MODIFICATION REQUEST: MP 07_0093 MOD 2 Modification to development of Lot 5 of Interlink Industrial Estate, Erskine Park

Lot 5 DP1124329 (formerly part Lot 141 DP 843899) Mamre Road, Erskine Park

Director-General's Environmental Assessment Report Section 75W of the *Environmental Planning and Assessment Act 1979*

February 2012

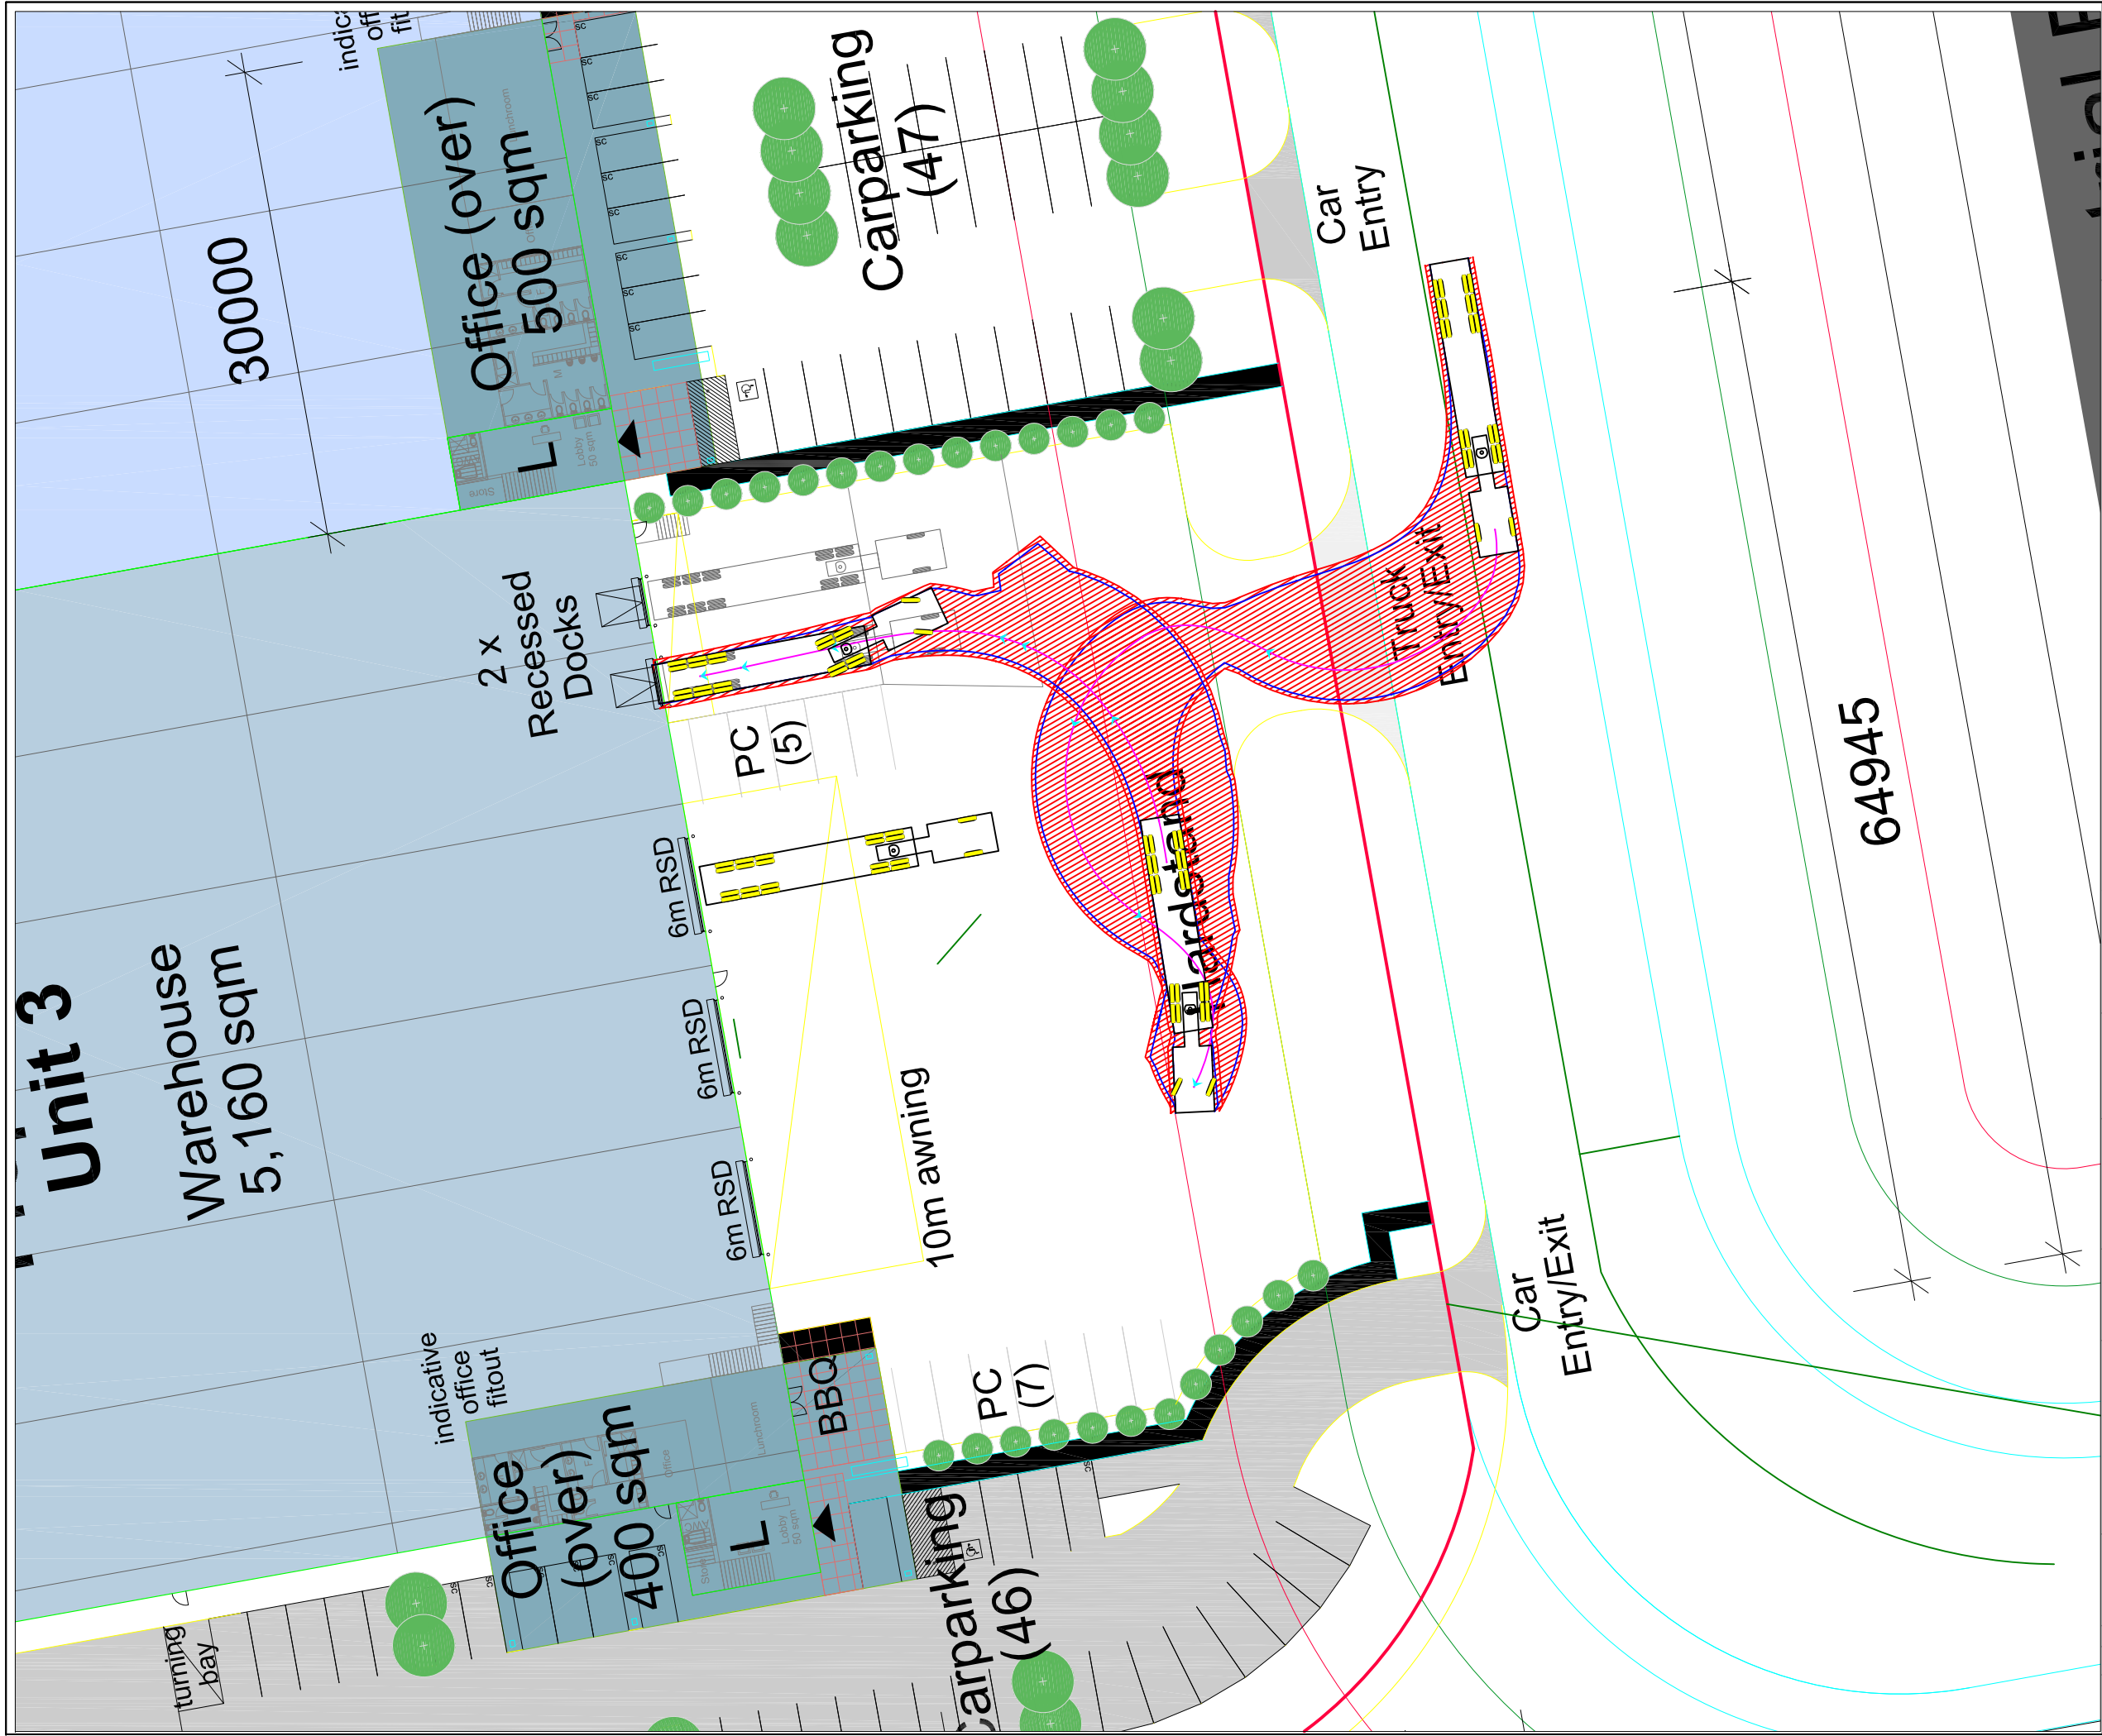
- the proposed development fails to satisfy Council's minimum requirements with respect to car parking rates,
- the arguments that the previously approved car parking rate could be applied to the proposed development form may not be appropriate given that car parking demands vary based on land use types and unit sizes,
- an appropriate ratio of car parking numbers is to be provided for each unit within the development.

The increased provision of parking spaces in the amended plans will now satisfy Council's minimum requirements with respect to car parking rates in respect to the increase in gross floor area. This matter is discussed in sections 5.1.3 and 5.5.2.

West (Mamre Road) Elevation - as APPROVED

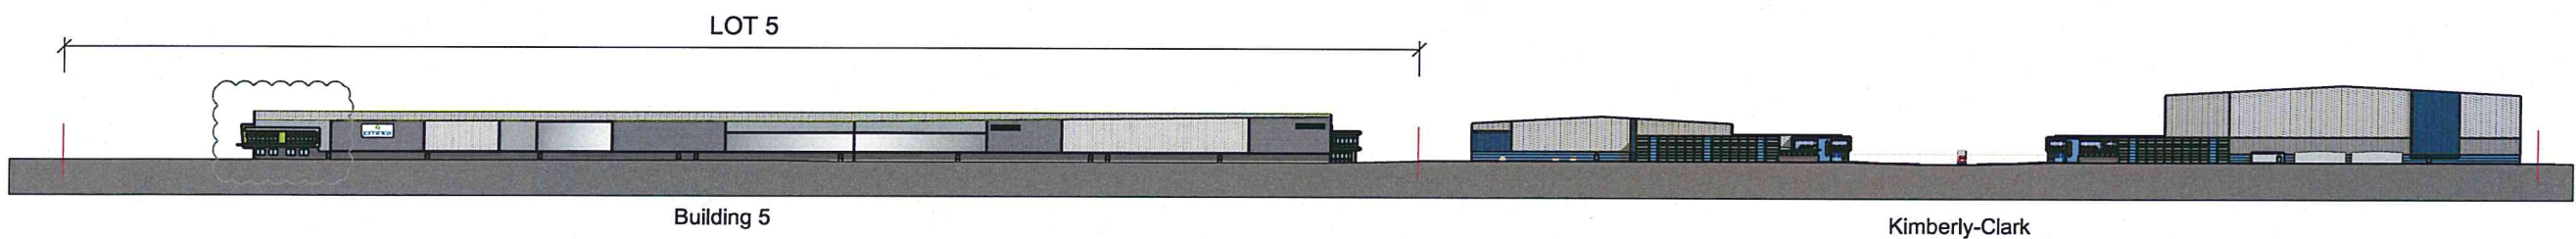
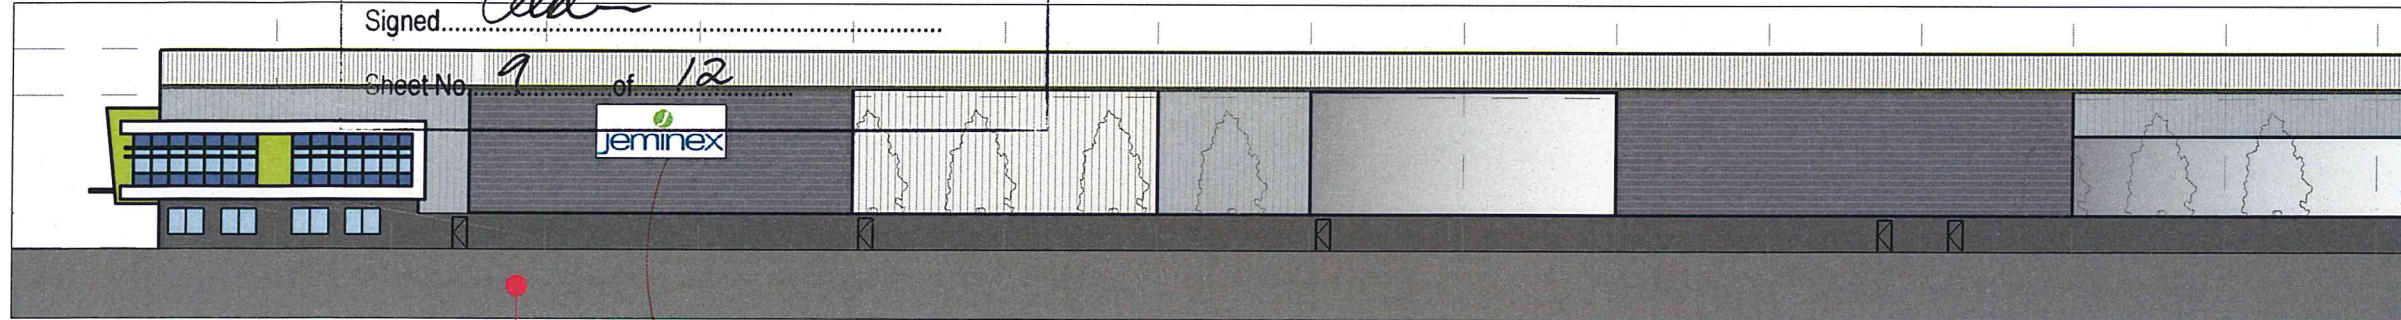
- council is concerned about the size of the building and the resulting visual impacts, particularly when viewed from Mamre Road,
- there is a need for appropriate articulation of the building form and consideration of the requirements for site development and urban design within Penrith DCP,
- the use of appropriate and varying building materials and colours is encouraged.

- landscaping should be designed to complement the development and reduce the visual impact of the building when viewed from Mamre Road,
- as noted in Penrith Development Control Plan 2006, "the visual impact of large expanses of wall should be reduced in scale by architectural treatment as well as by dense grove planting or other landscape design solutions".

As indicated above, the modified development provides for a single large building. This will have a facade length of approximately 300m to the western elevation along the Mamre Road frontage of the site. This will be the most visible continuous elevation, when viewed from outside the estate. It is also noted that the building will stand on top of an approximately 2.5m high embankment to Mamre Road. The facade length of the modified development compares to the approved project where two separate buildings were proposed with facades lengths of approximately 127m and 130m, to Mamre Road, and with approximately 45m separating the two buildings.

In response to issues raised by Penrith City Council regarding the visual impacts of the modification and landscaping of the development, the proponent has advised that any issues can be overcome by use of increased architectural treatment and through successful landscaping, albeit that market demands for a large warehouse style buildings can limit the architectural treatment that can be undertaken.

The modification provides for an appropriate mix of external colours and finishes including a mixture of precast concrete dado panels and various colours for external metal sheeting.

The existing conditions of approval include a requirement in condition 22 that prior to commencement of construction the proponent revises detailed plans for the facades for unit 5A and lot 1, in consultation with Council and to the satisfaction of the Director-General. The development on lot 1 has been completed. In regard to unit
